Application Ref:	3/2026/0322			 Ribble Valley Borough Council www.ribblevalley.gov.uk
Date Inspected:	22/7/25	Site Notice:	19/5/26	
Officer:	BT			
DELEGATED ITEM FILE REPORT:				APPROVAL

Development Description:	Reserved Matters Application for appearance, landscaping, layout and scale for the erection of a farm worker's dwelling (self-build).
Site Address/Location:	Land at Lower Standen Hey Farm, Whalley Road, Pendleton, BB7 1PP.

Title: Proposed Elevations

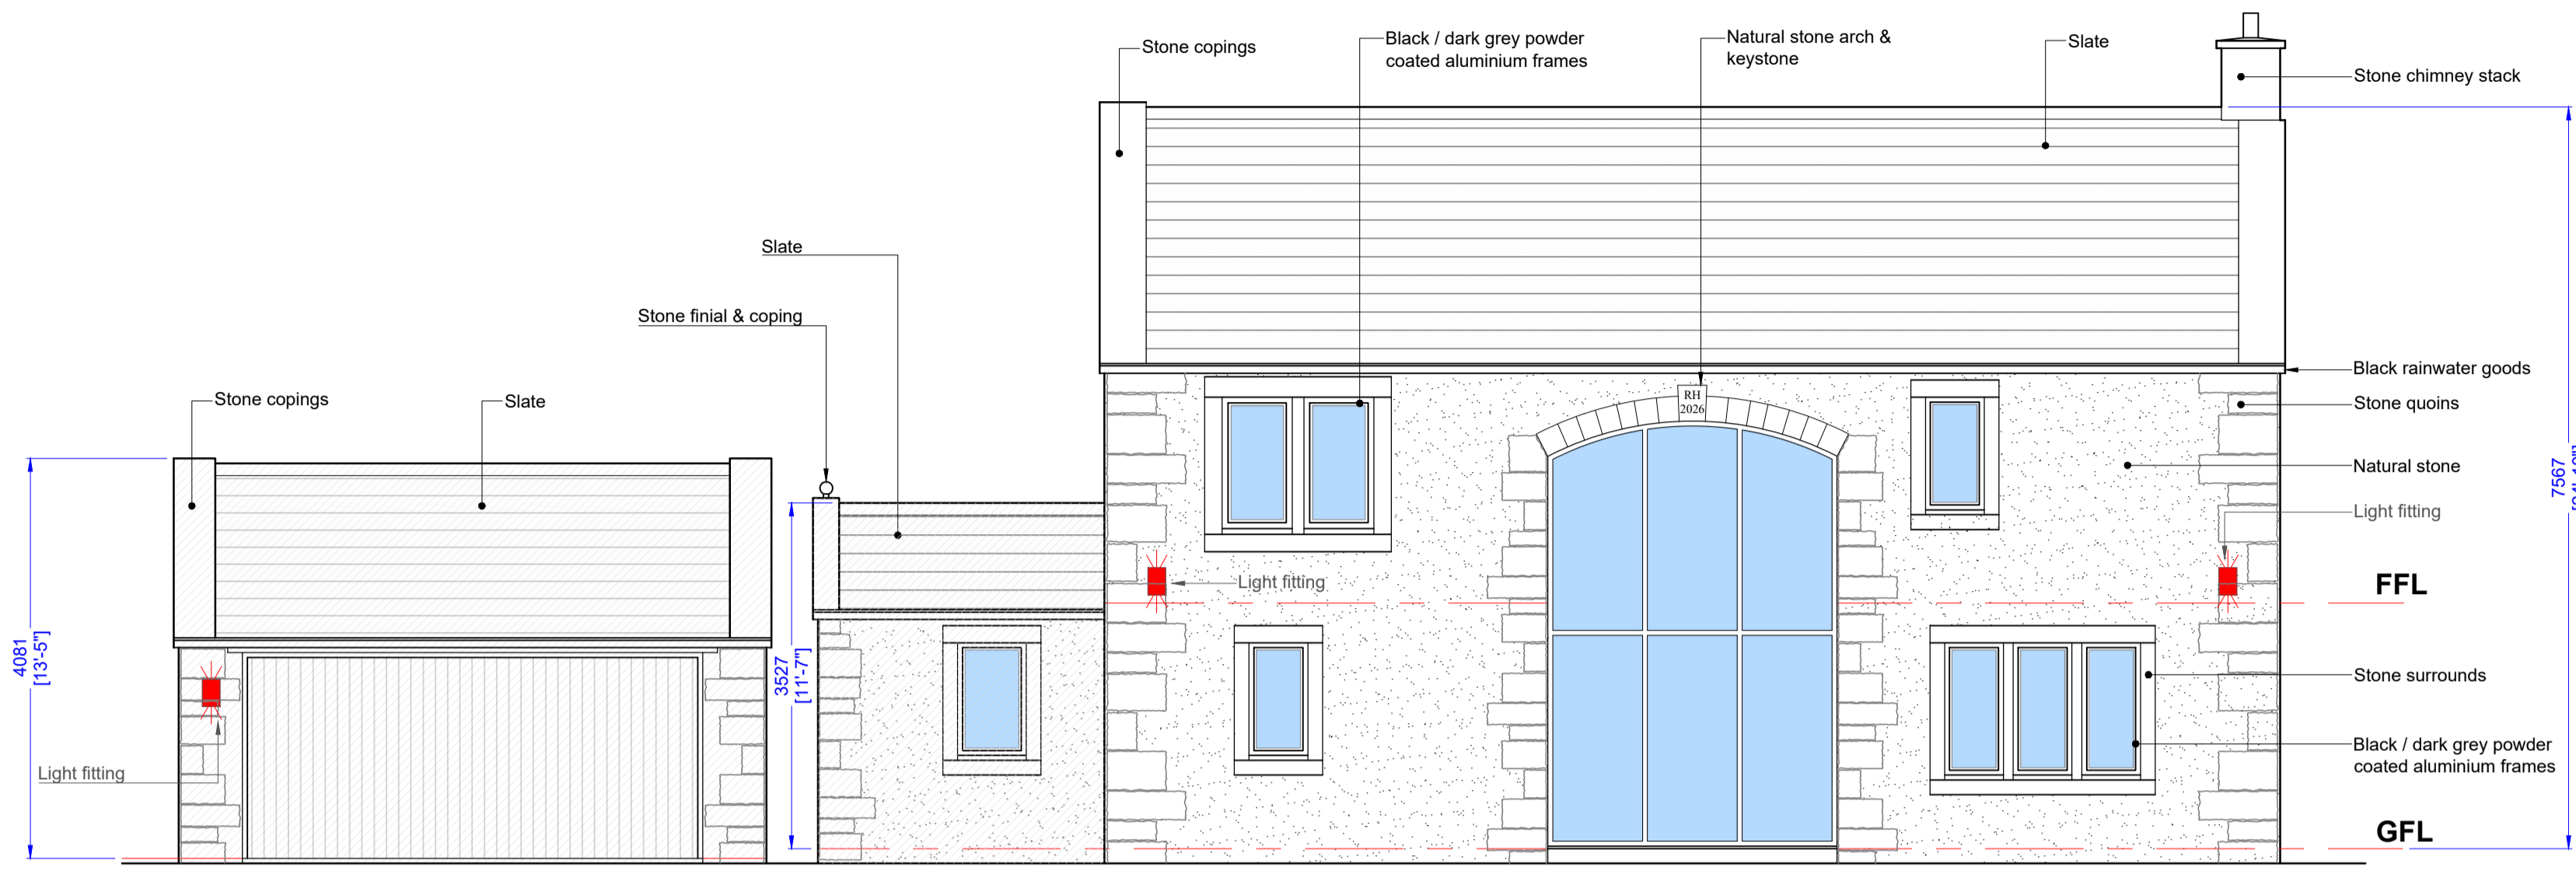
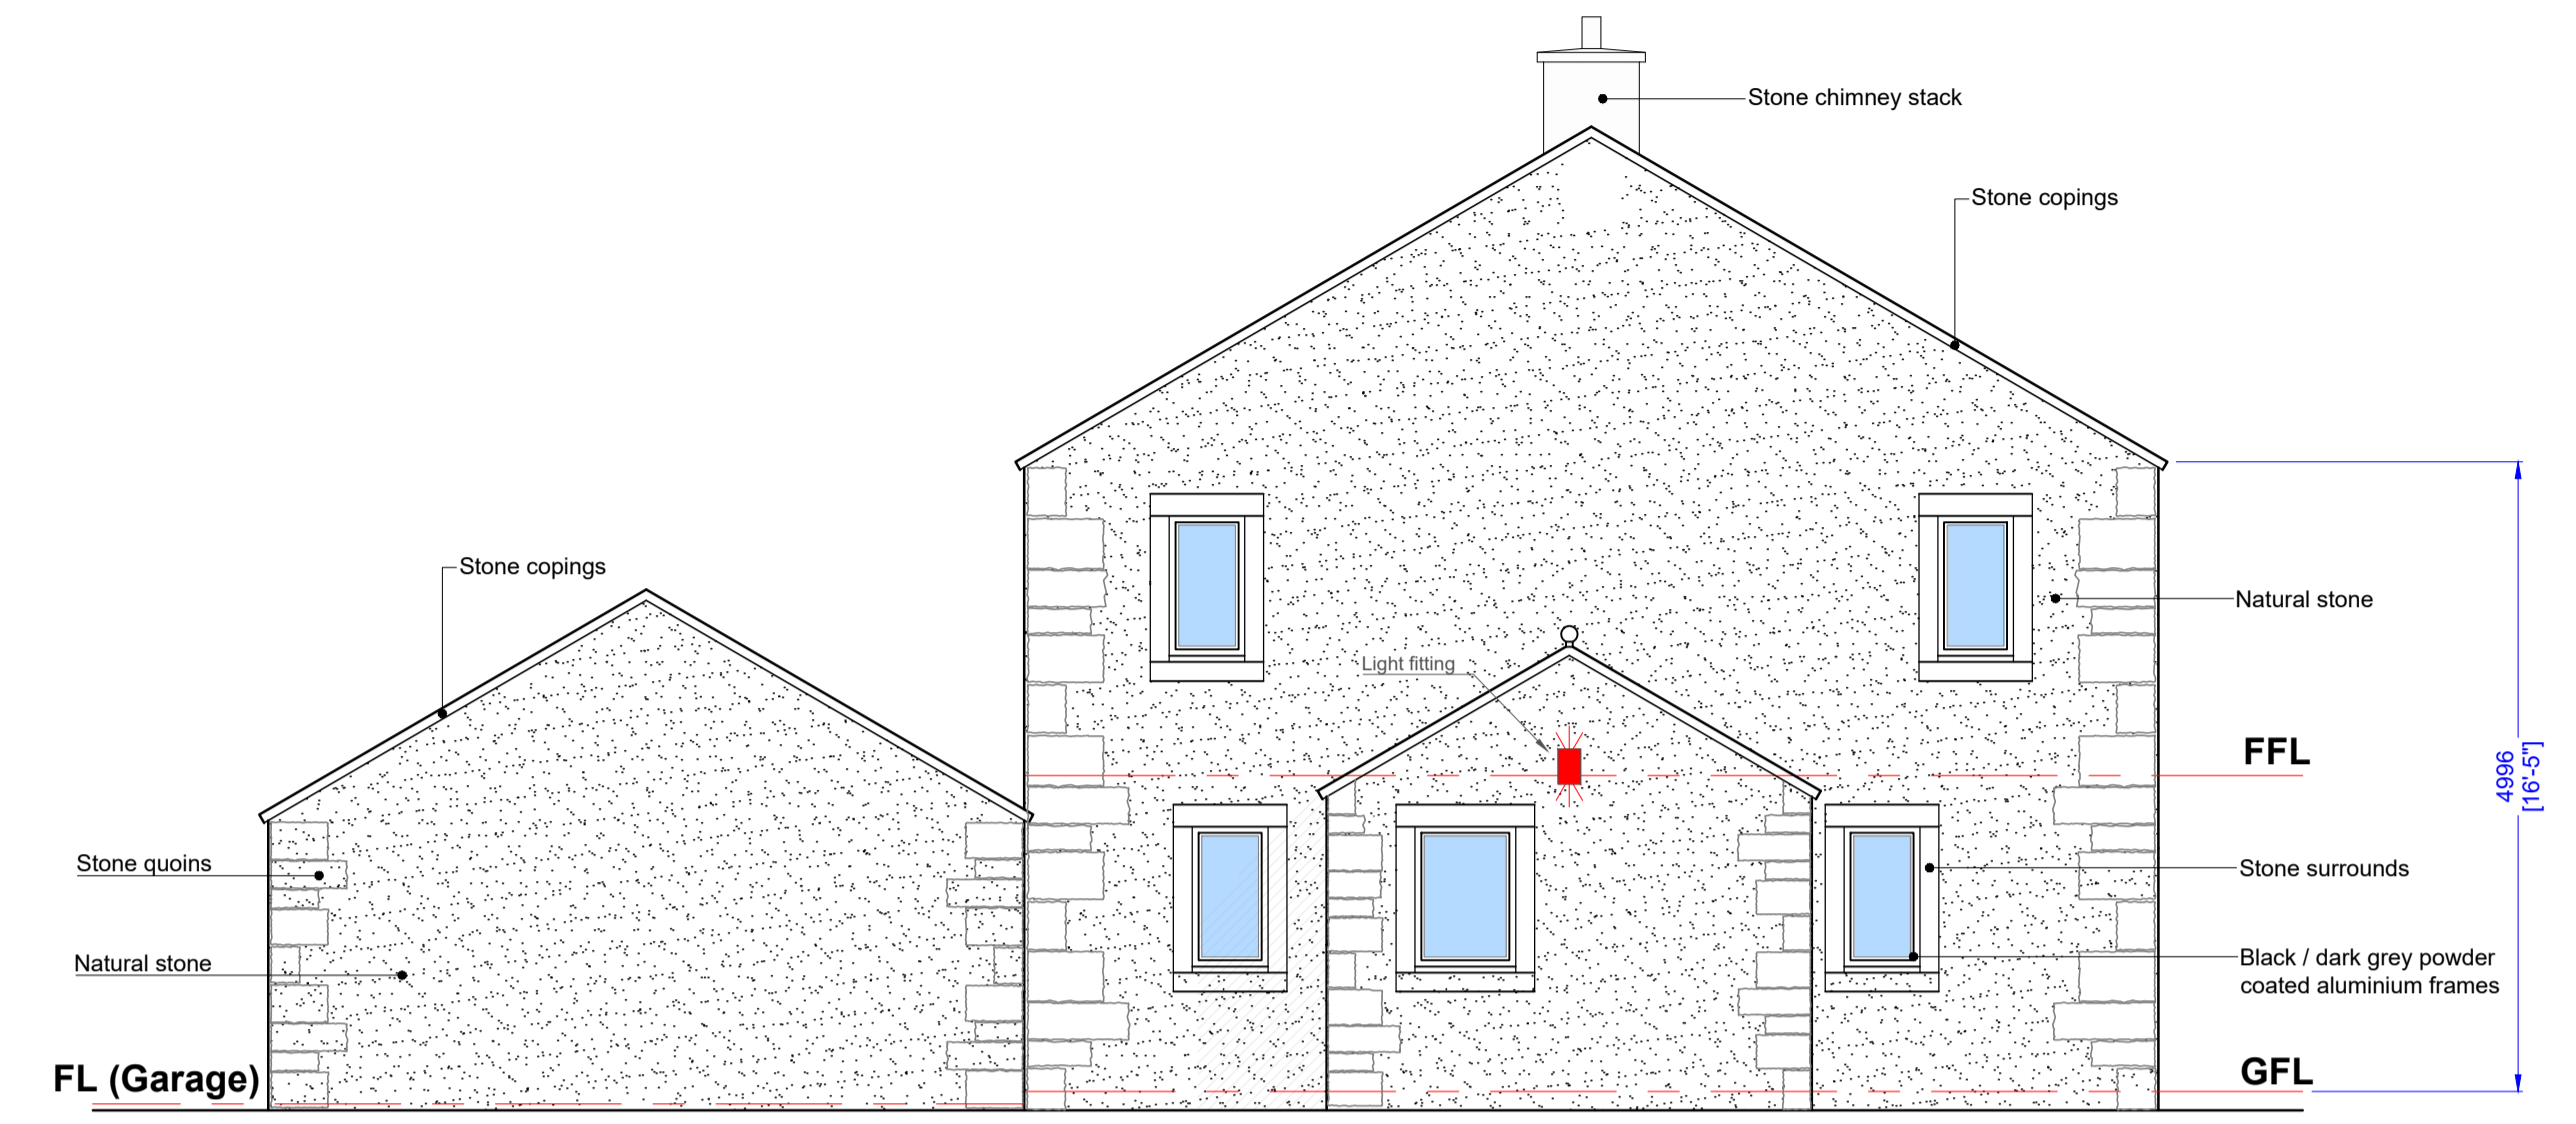
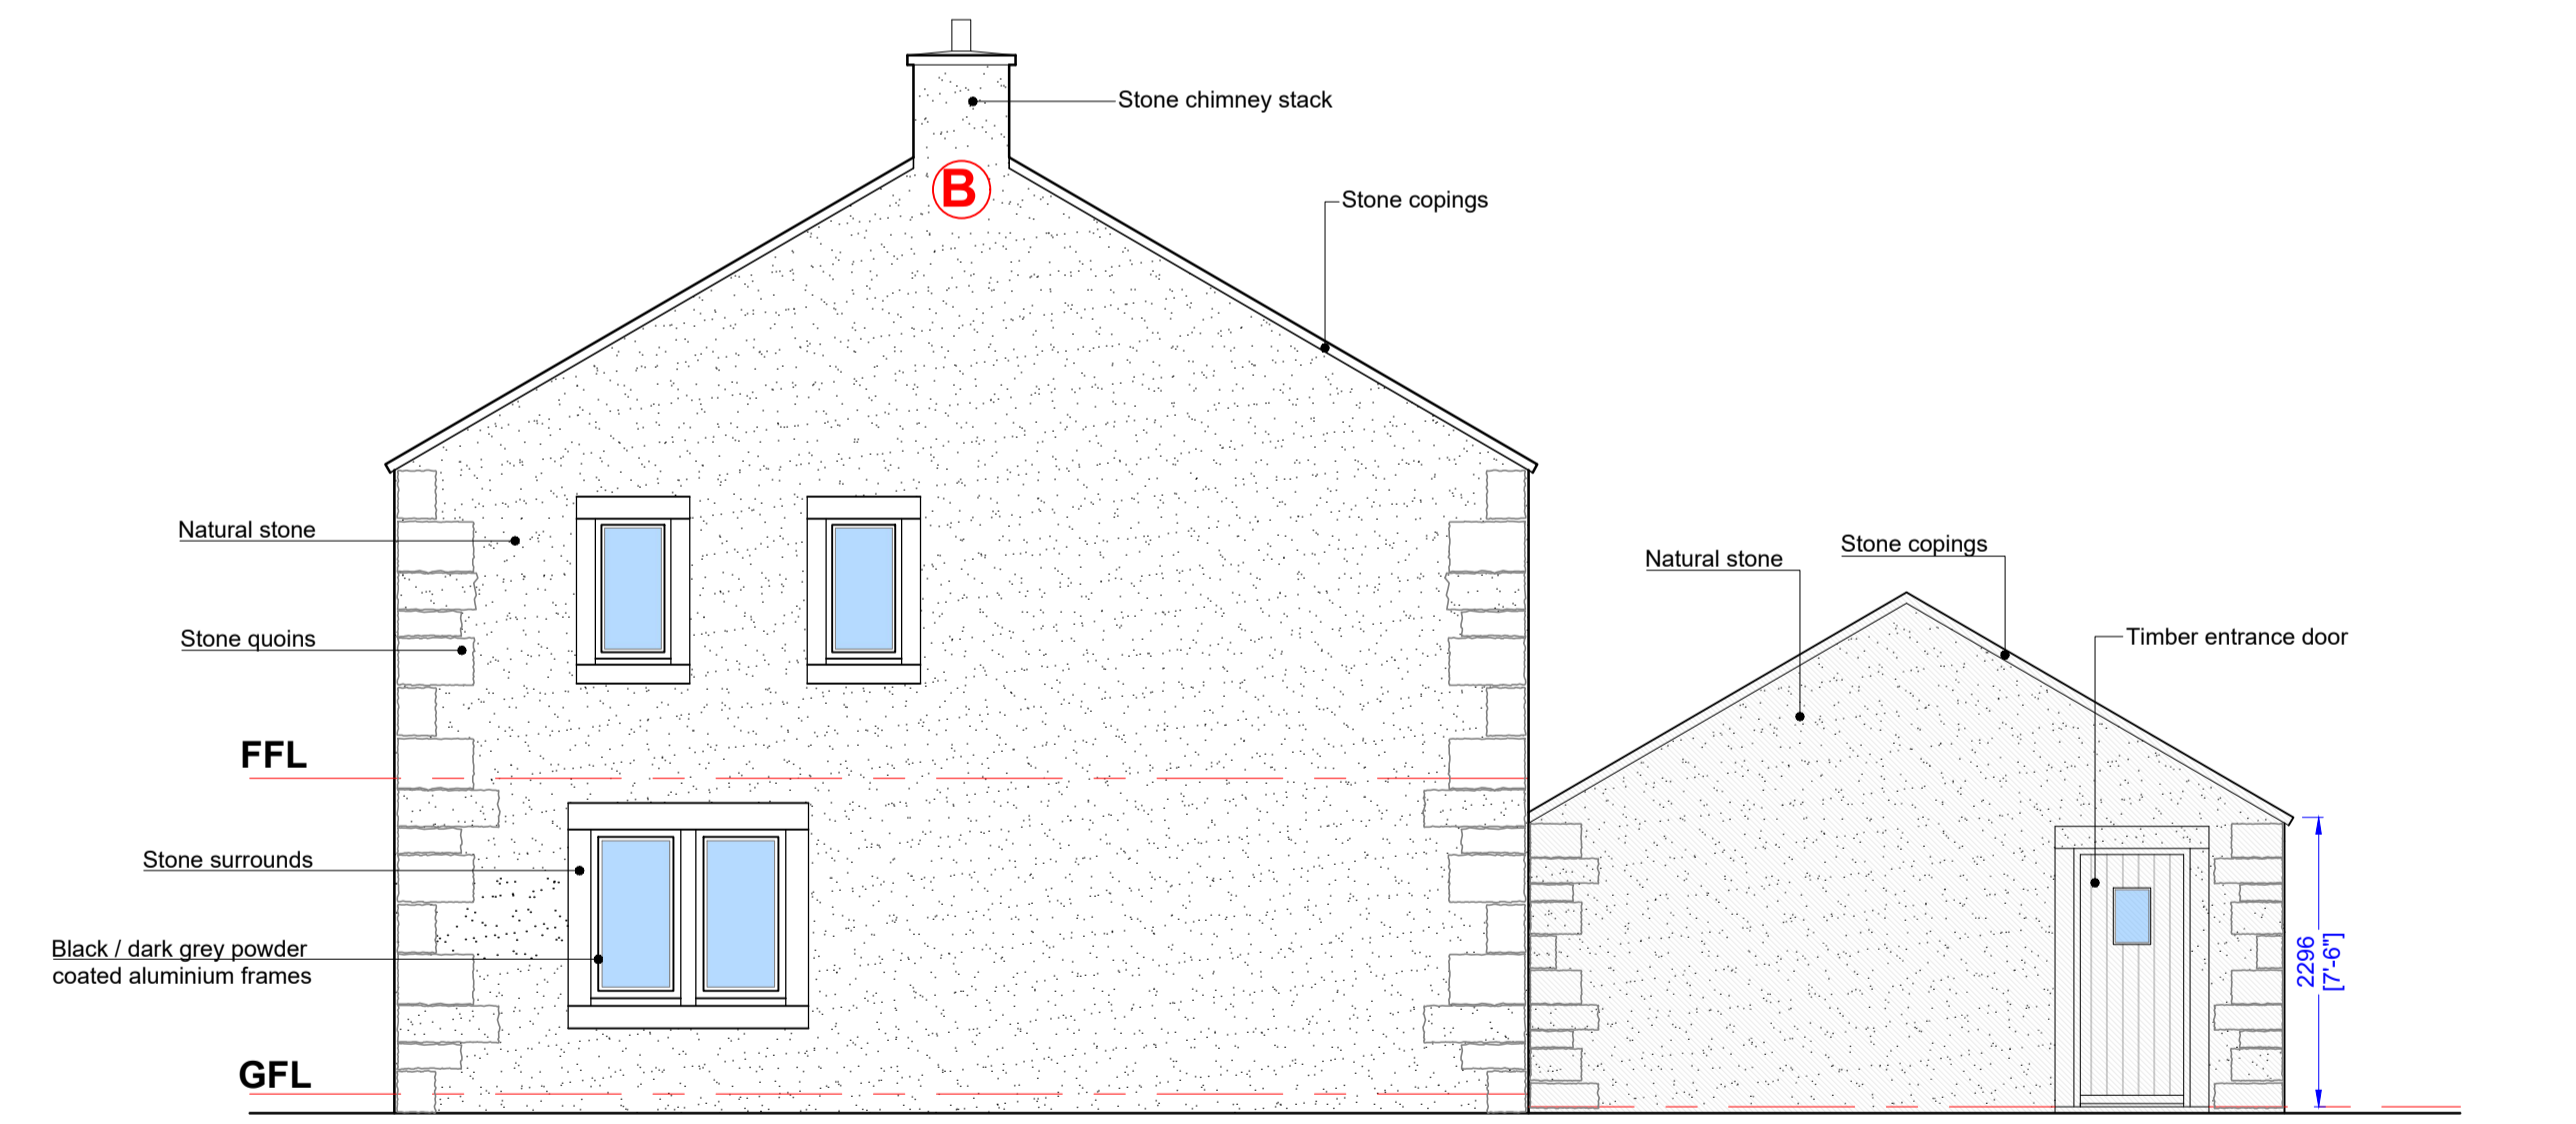
In this instance, the proposal seeks to introduce a two storey dwelling to the proposal site which lies within the open countryside however the proposed dwelling is not considered to be oversized with regards to its height, footprint or cubic volume and would be sited in close proximity to existing buildings within the site which include a sizeable portal frame agricultural building, polytunnel and open sided timber frame storage building. Furthermore, the submitted plans show that the proposed dwelling would be set into the site approximately 20 metres away from Public Right Of Way FP0332010 with the interior of the application site also being well screened by an existing tree line which runs along the site’s South-eastern perimeter. As such, the proposed dwelling would read as a proportionate addition to the site that would be read in the context of the site’s existing built form. In addition, the proposed dwelling would be detailed in stone and slate which would be wholly in keeping with the rural vernacular of dwellings within the locality and would therefore read as a congruent addition to the site in the context of the site’s rural setting. Similarly, the proposed detached garage would be a modestly sized structure detailed in stone and slate and as such would read as an acceptable addition to the proposal site.

The applicant was asked to give consideration to incorporating a more traditional pattern of fenestration in terms of window layouts and sizes in addition to the use of timber window frames however after consideration the applicant has stated preference to retain the submitted scheme of fenestration. Notwithstanding this, whilst the retention of the existing scheme of fenestration is considered to be less than desirable, given that the proposal is otherwise considered to be acceptable with respect to its design and external appearance it is not considered that this alone provides sufficient justification for refusal of the application.
